OBJECTION: MIXED-USE DEVELOPMENT MACKENZIE ST, LAVENDER BAY SSD-88702457

I am the owner and resident of 12 Wilona Avenue, Lavender Bay. My home is an early 1900s single storey terrace and is identified as a contributory item within the Lavender Bay Heritage Conservation Area, it is directly across the road from the development site and is one of the properties most immediately affected by the proposed development.

1 : 100

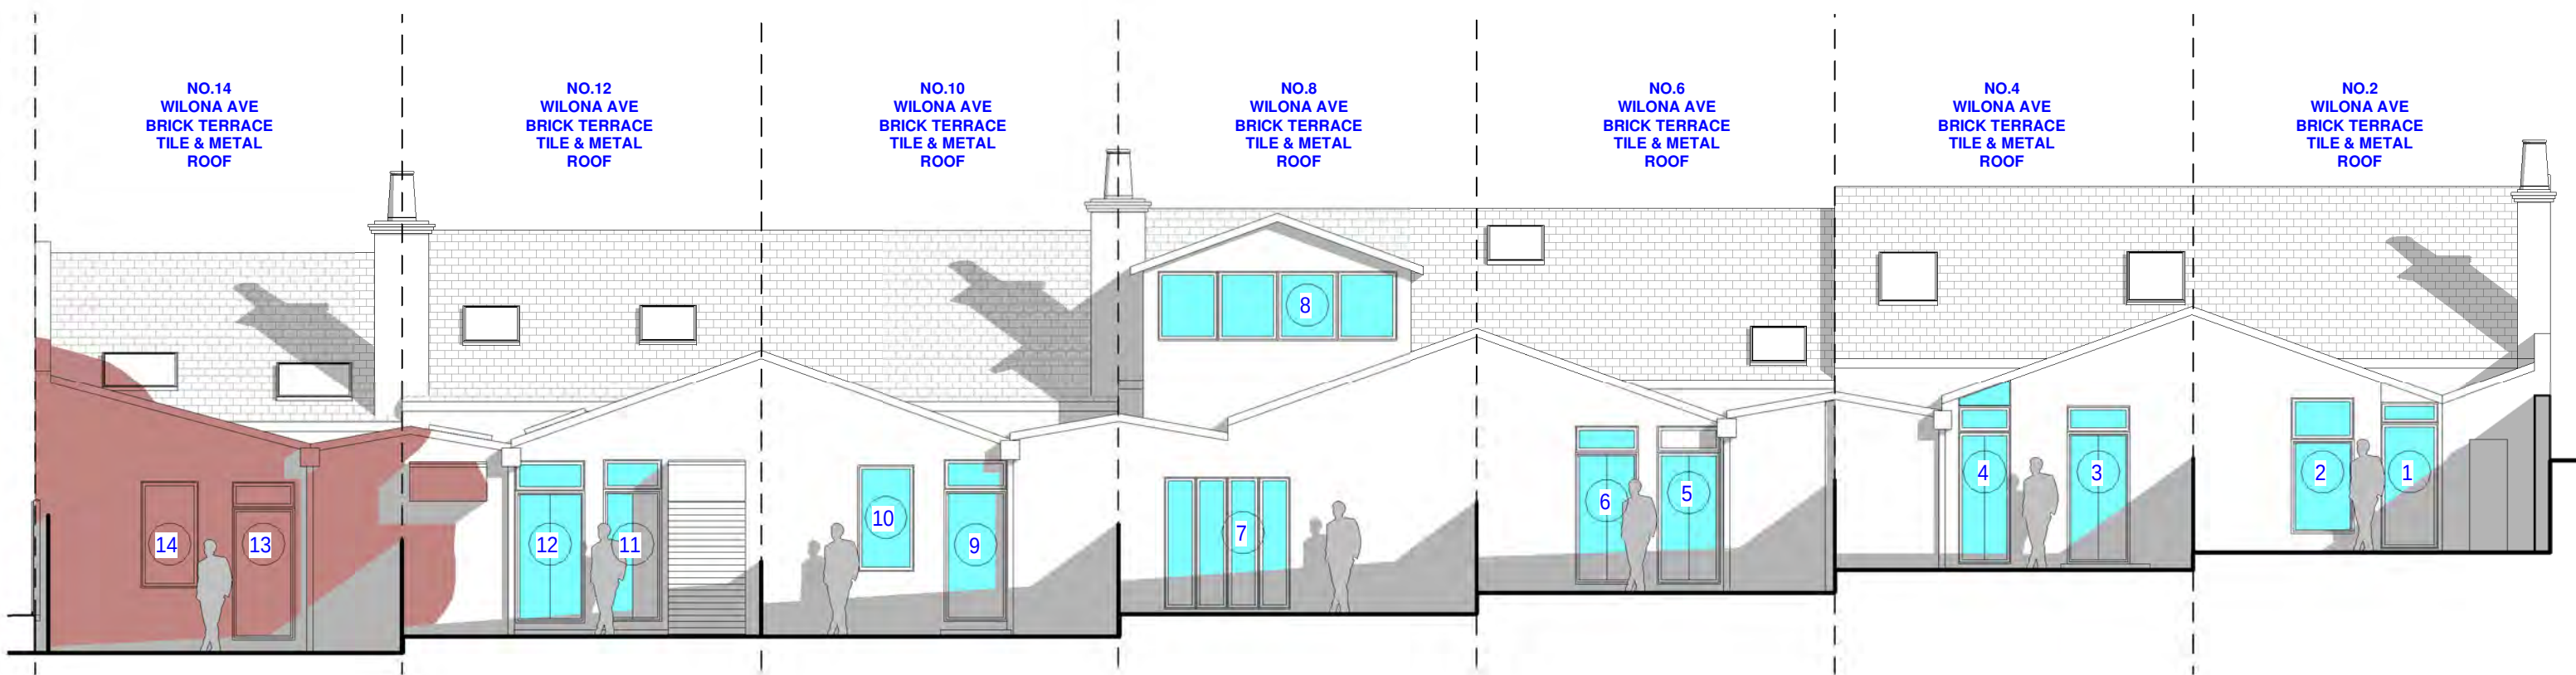
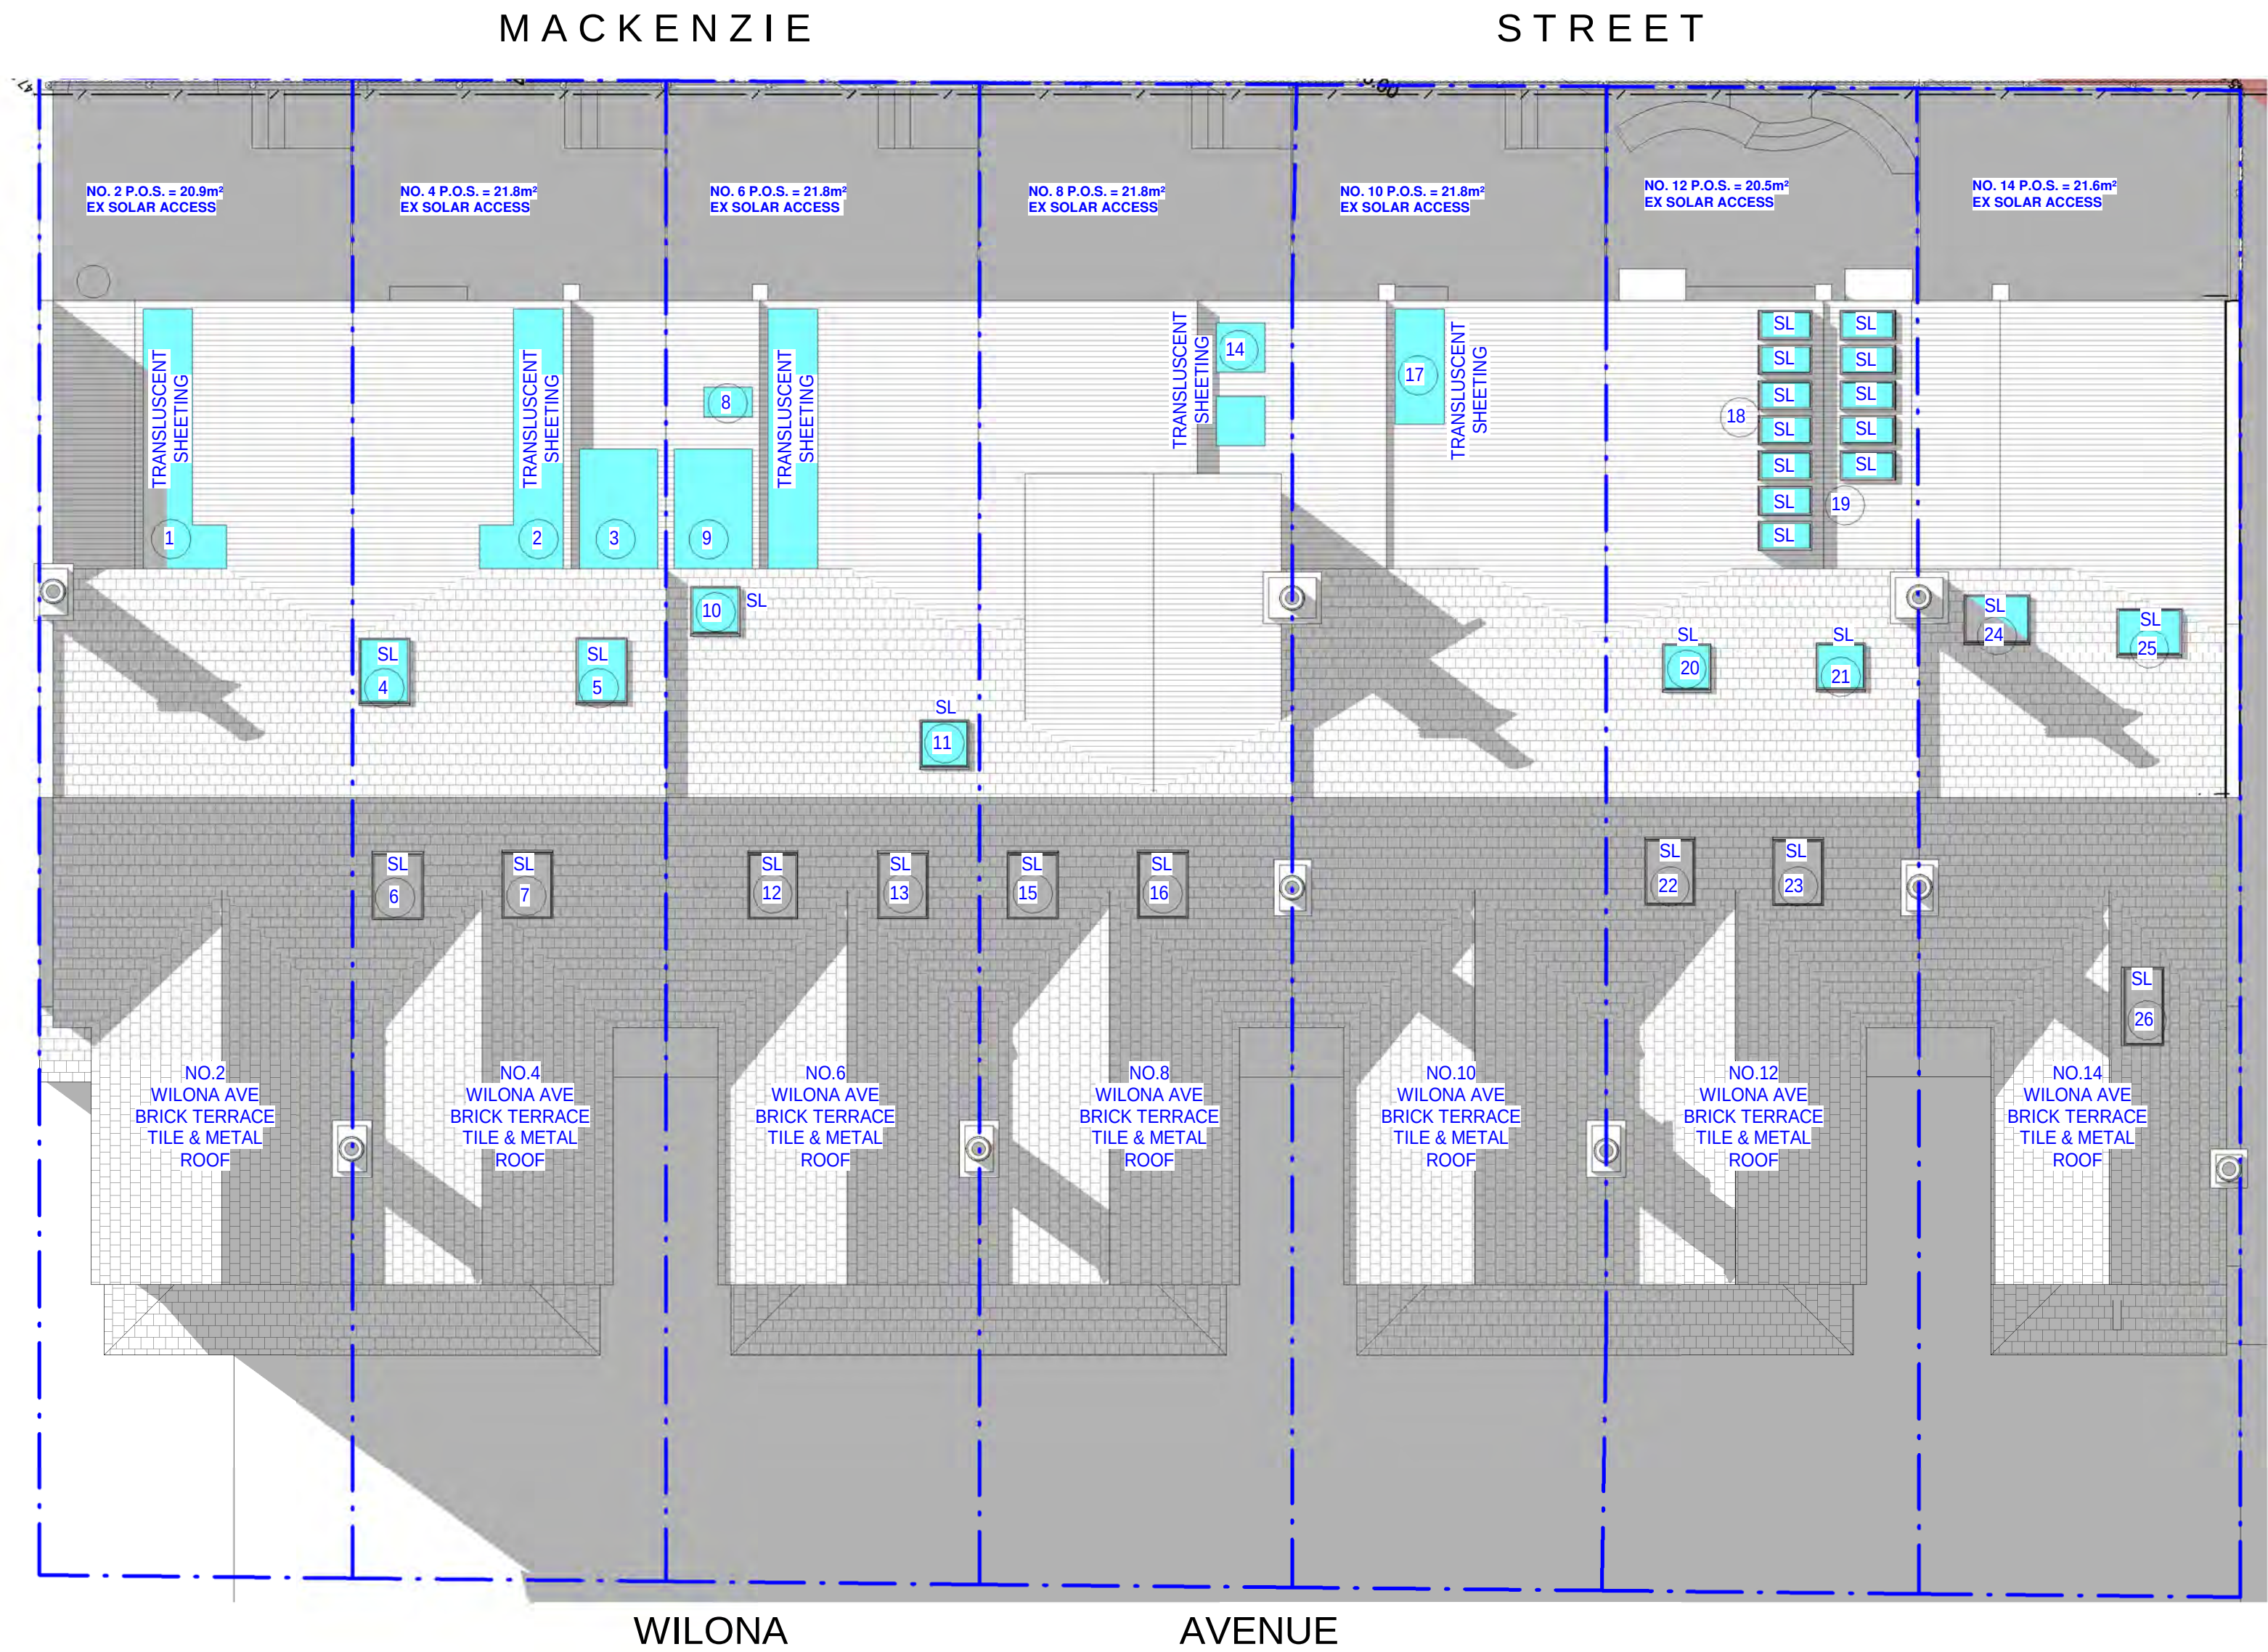
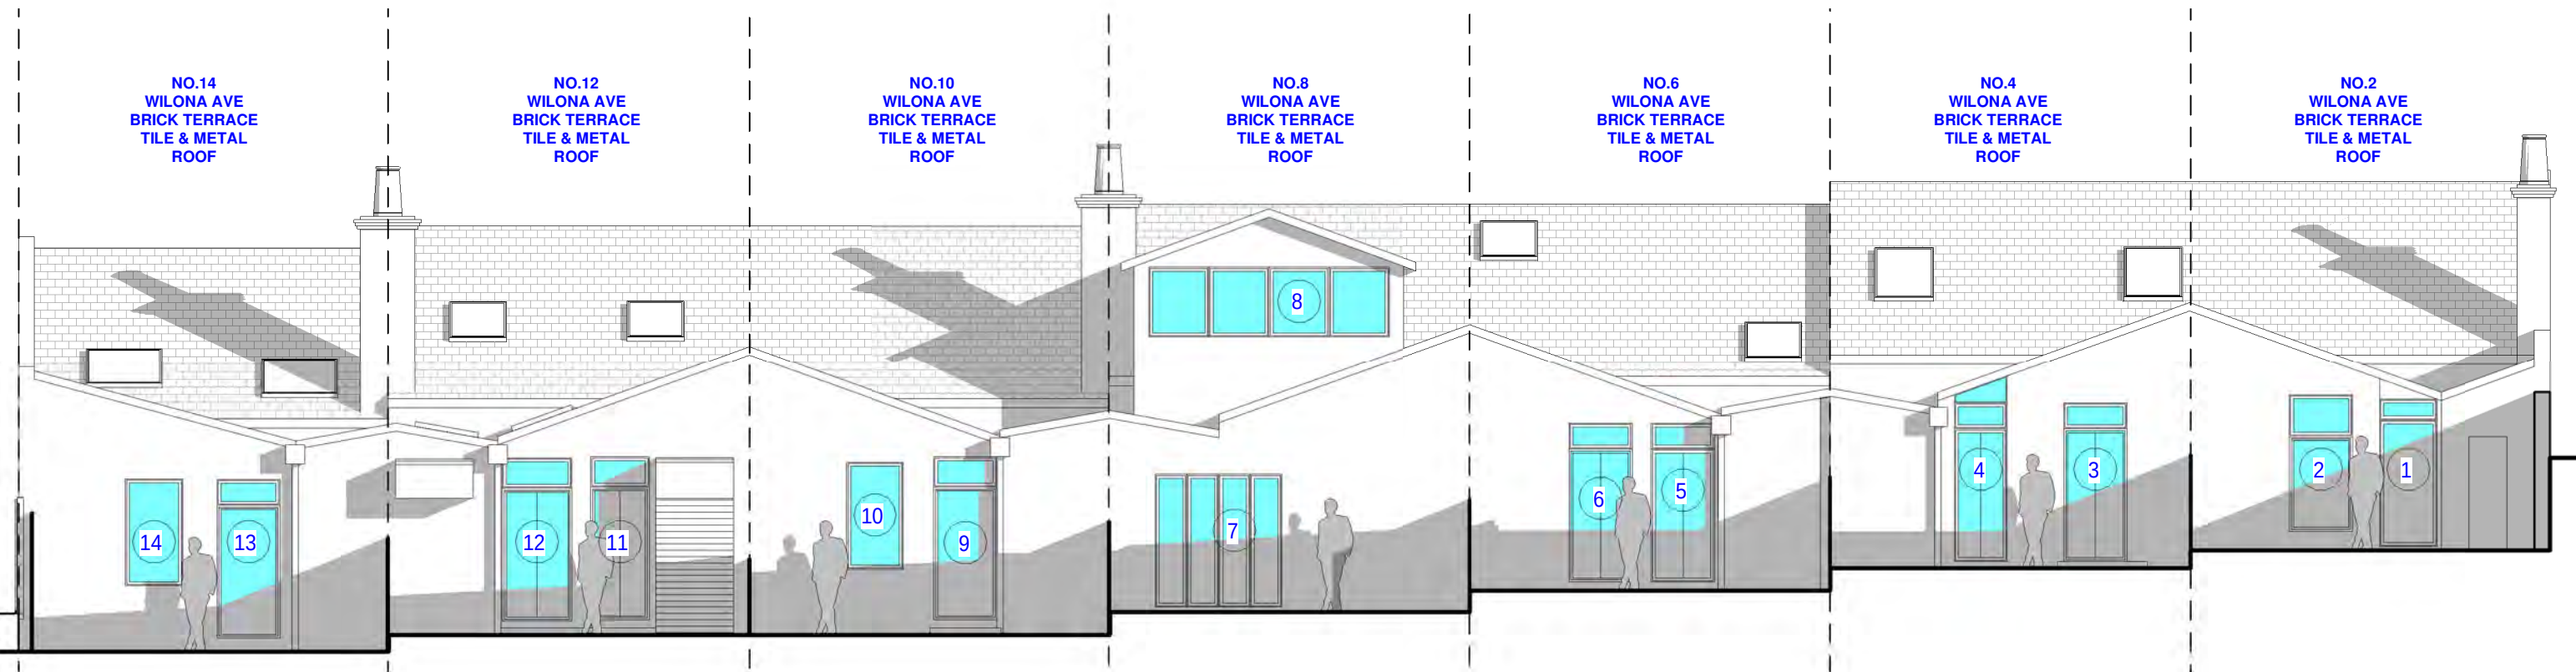
The loss of solar access to my home is another one of my strongest objections to this proposal. I live directly opposite the development and the independent solar analysis commissioned shows that the impact on 12 Wilona Avenue will be severe.

This is not a minor reduction at the margins. The proposed development will remove between 50% and 67% of the existing winter solar access to the windows serving my principal living areas. My main living area currently receives approximately 3 hours of solar access on 21 June and would be reduced to 1.5 hours. My kitchen currently receives approximately 6 hours and would be reduced to only 2 hours. These two spaces are used most frequently in our home, they are both our main living areas perhaps because they are the two areas with solar access. Being a single storey terrace house solar access is limited to the centre and southern side of the house our main living area naturally exist in the northern side of the house and we spend the majority of our time there.

The effect on the skylights that provide natural light to my home is even more serious. Of the six skylights/roof areas assessed at No. 12, five lose between 60% and 100% of their existing winter solar access. Two lose all of it, reducing from one hour of direct sunlight to zero. The remaining skylight still loses 50%.

The elevations show people standing within the courtyards and allow the shadow to be assessed at human height, not just at ground level. The northern elevation specifically includes No. 12 Wilona

Avenue and shows the relationship between the additional development shadow and the areas actually occupied by residents.
